**RE: 250 Commercial St., BP# 2016-03039 building code plan review comments
Liquid Riot**

Attached are revised drawings and literature for the storage room at Liquid Riot. Also see the responses to your comments below, outlined in red.

A1.01

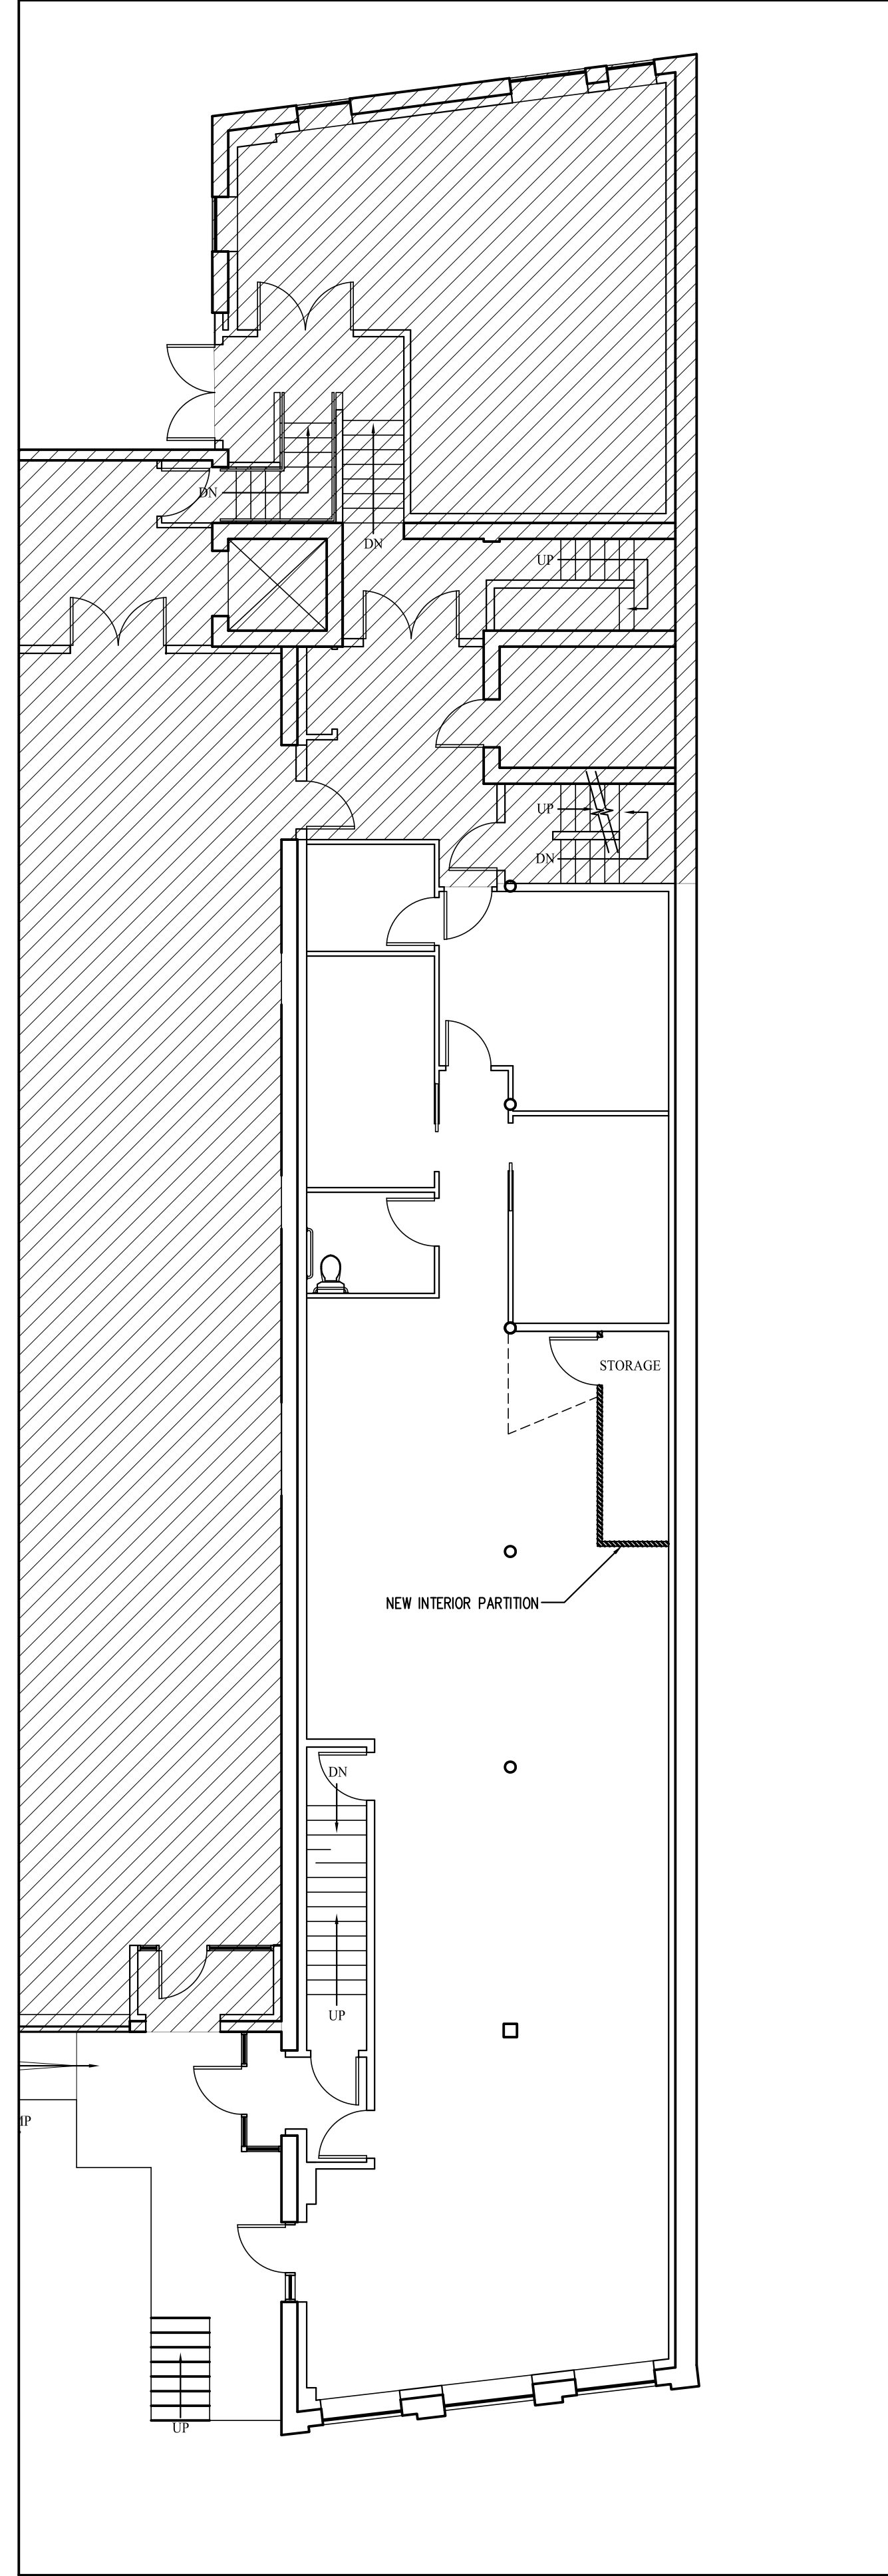
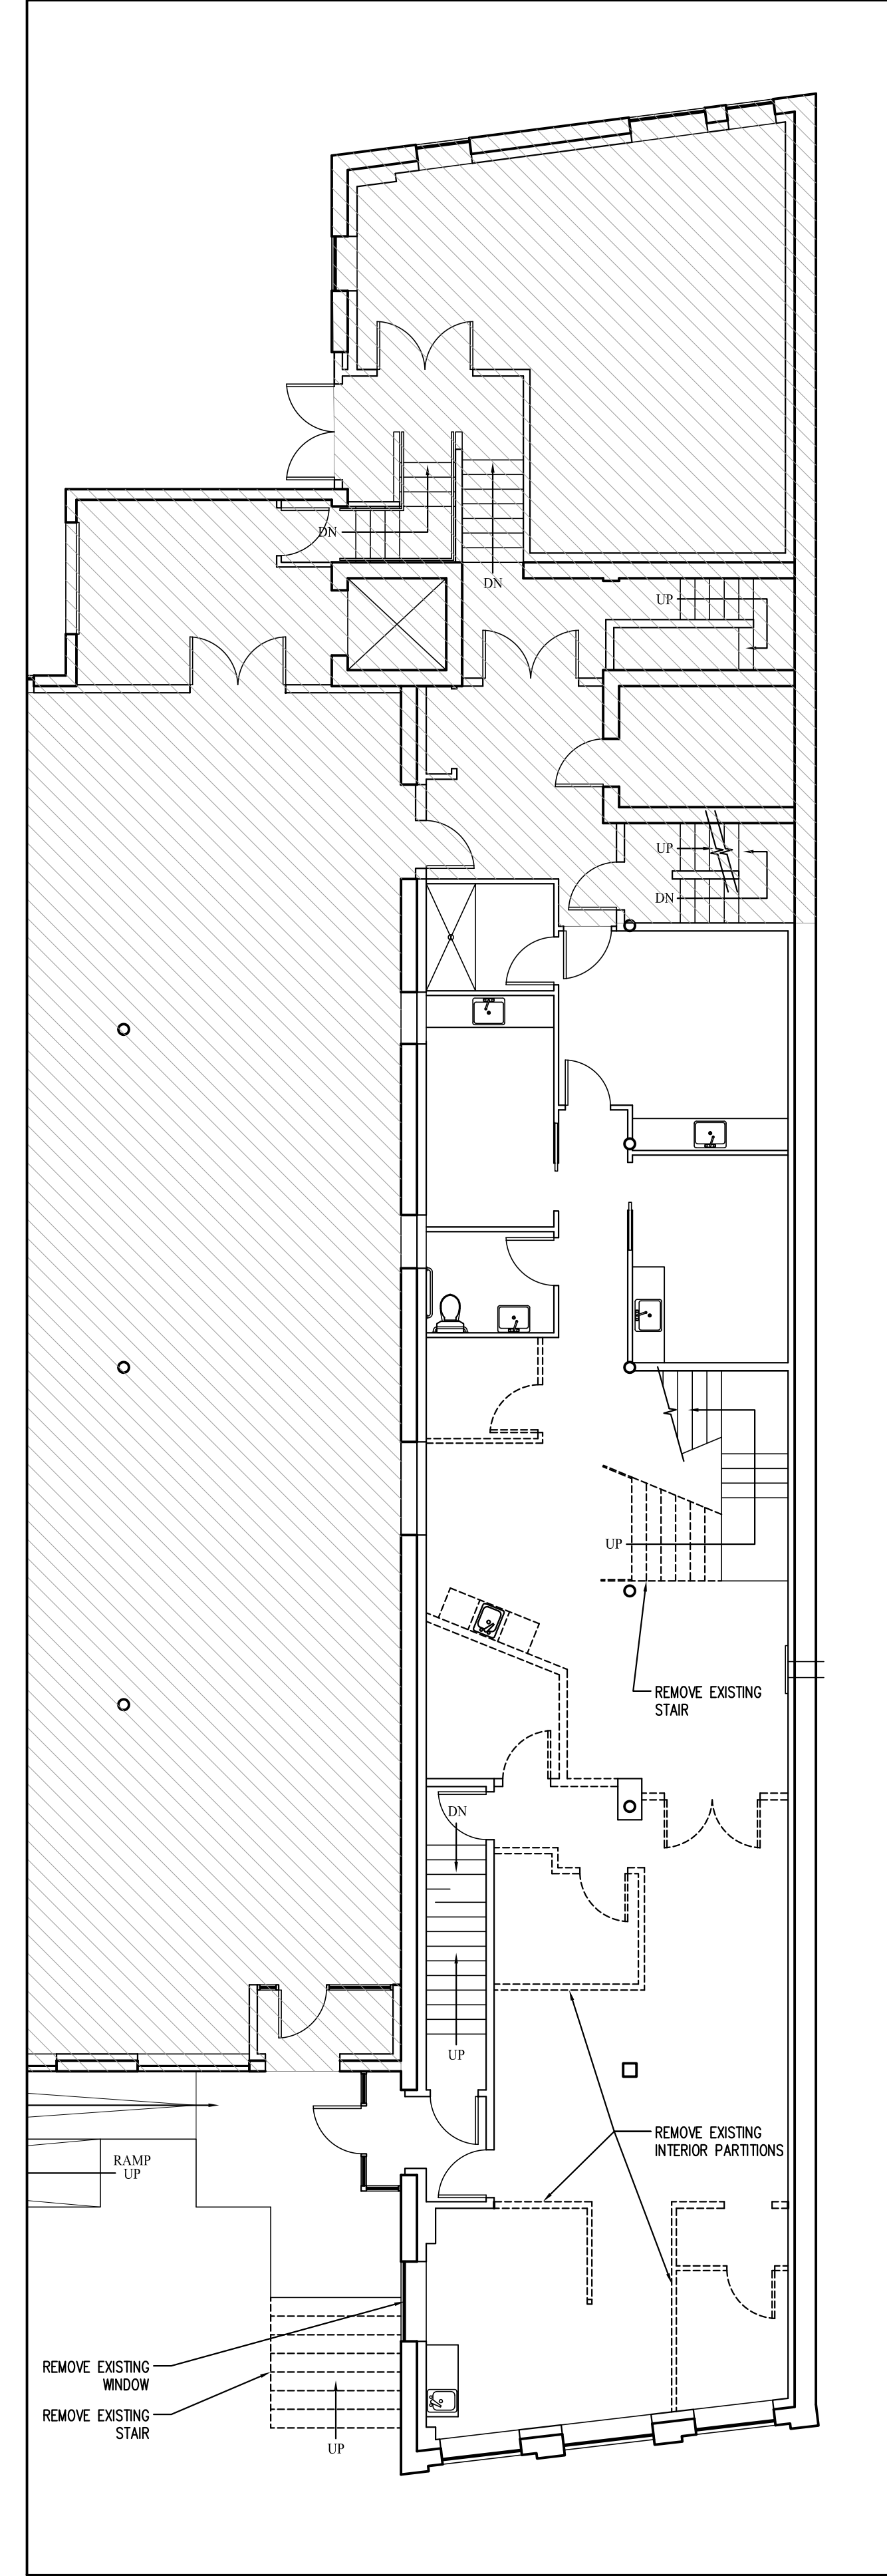
2. Provide a key plan of the total 2nd floor that shows the area occupied by Liquid Riot in context to other occupied space on the 2nd floor, including all exits.

See Key Plan attached.
